The Independent Expert (Brain Hemsworth) made comments on the *Noise Scheme of Assessment (NSoA)* for *Route Section E* on 1st July 2015. The key concern was that the location of “Dr Booths C.E School” should be correct in the NSoA, and that it has been considered in the NSoA. The relevant extract from the original IE comments are as follows:

2.School Location within Route Section E.

This note responds to those concerns by identifying the building, its location, the predicted noise levels and the need for noise mitigation.

**Figure 5.1 Location of Noise Barriers, Noise Contours Showing Extent of Noise Insulation and Residual Noise Levels from the Order Scheme**

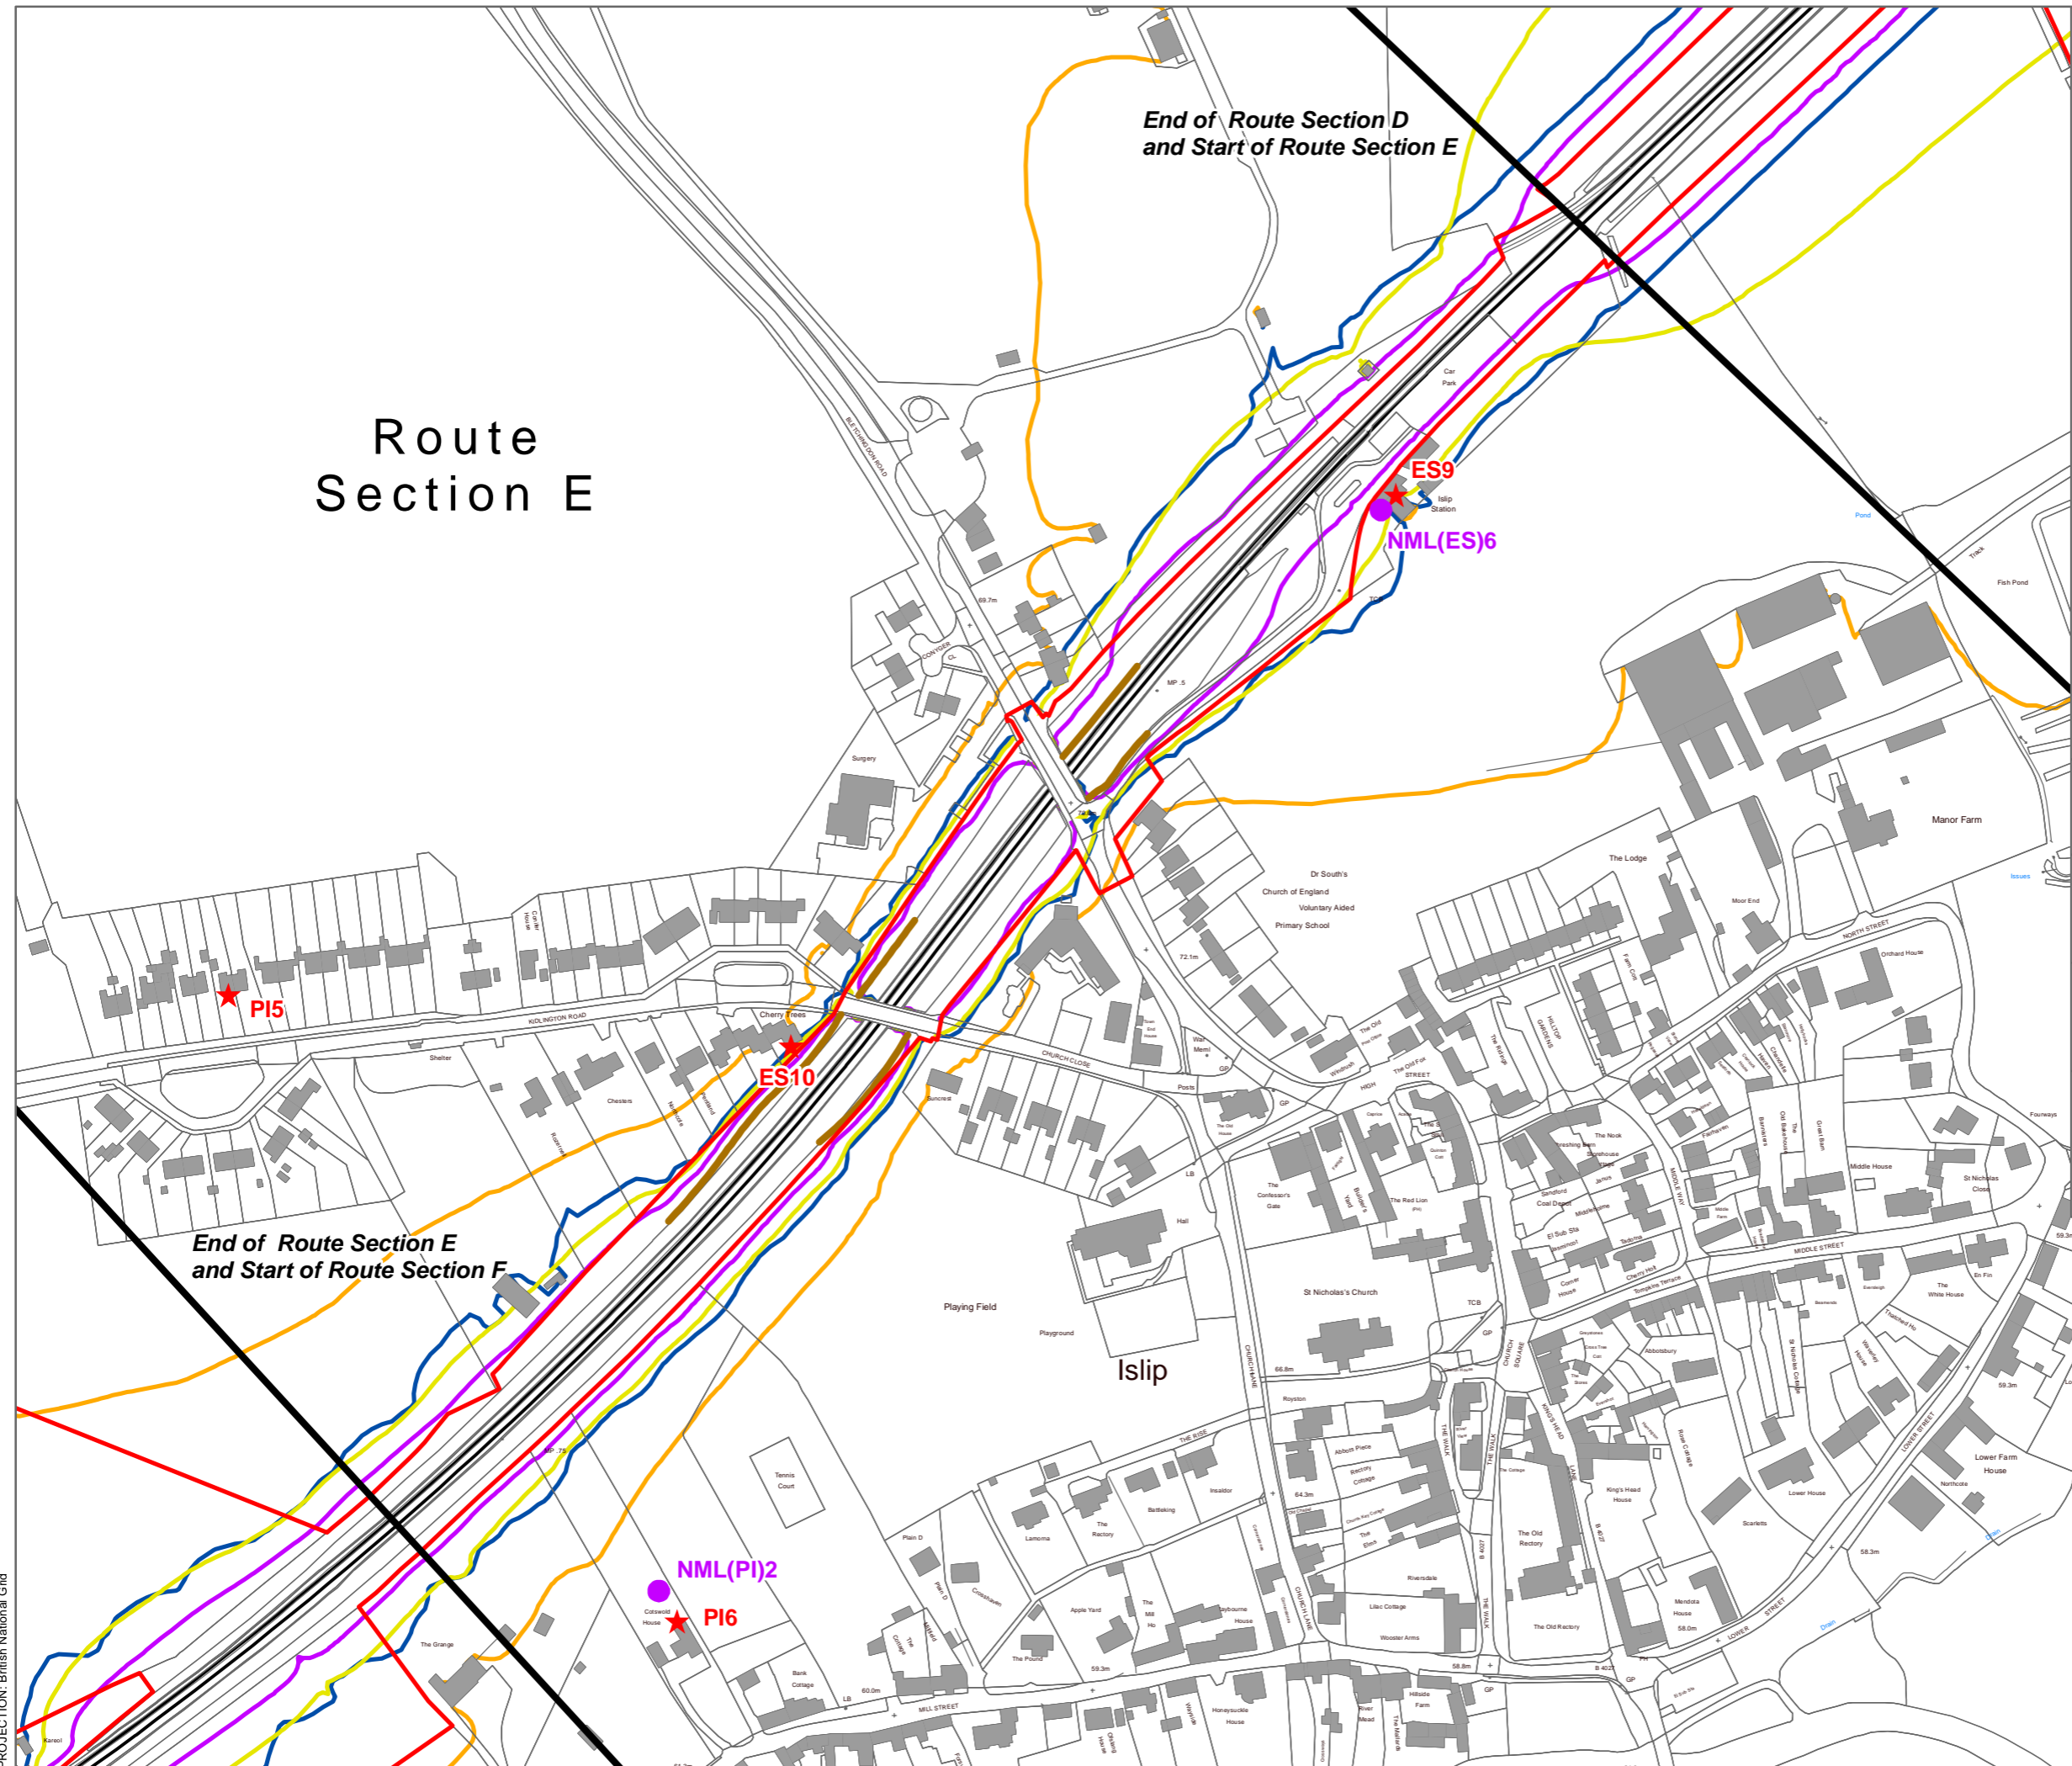
“1. Operational impacts are discussed in Section 6.4.2 but Dr Booth’s C.E. Primary School is not included. Neither is it identified as a Noise Sensitive Receptor in the NSoA for Route Section E or any geographical data for its location relative to the railway or noise levels given. Since it was not included on the NSoA it was not possible for me to comment on noise levels.

Criticism was correctly made that Dr Booth’s Primary School was incorrectly placed on the NSoA maps. This should be addressed as in comment 1”.

ERM has reviewed the mapping and maintains that the School is correctly included in the noise modelling. *Figure 5.1* in the NSoA showing the noise contours does include the building, although it is recognised that the label is some distance from the School. Although results are not tabulated for this receptor specifically, it was taken into account when designing the mitigation. The School and the proposed railway lines as modelled are shown in *Figure 2.1*.

Since the noise levels do not exceed the *Noise Impact Threshold* for daytime by more than 3 dB, no noise mitigation is required either in terms of noise control at source, through noise barriers or noise insulation. The NSoA did consider this receptor and the mitigation in the NSoA is robust.
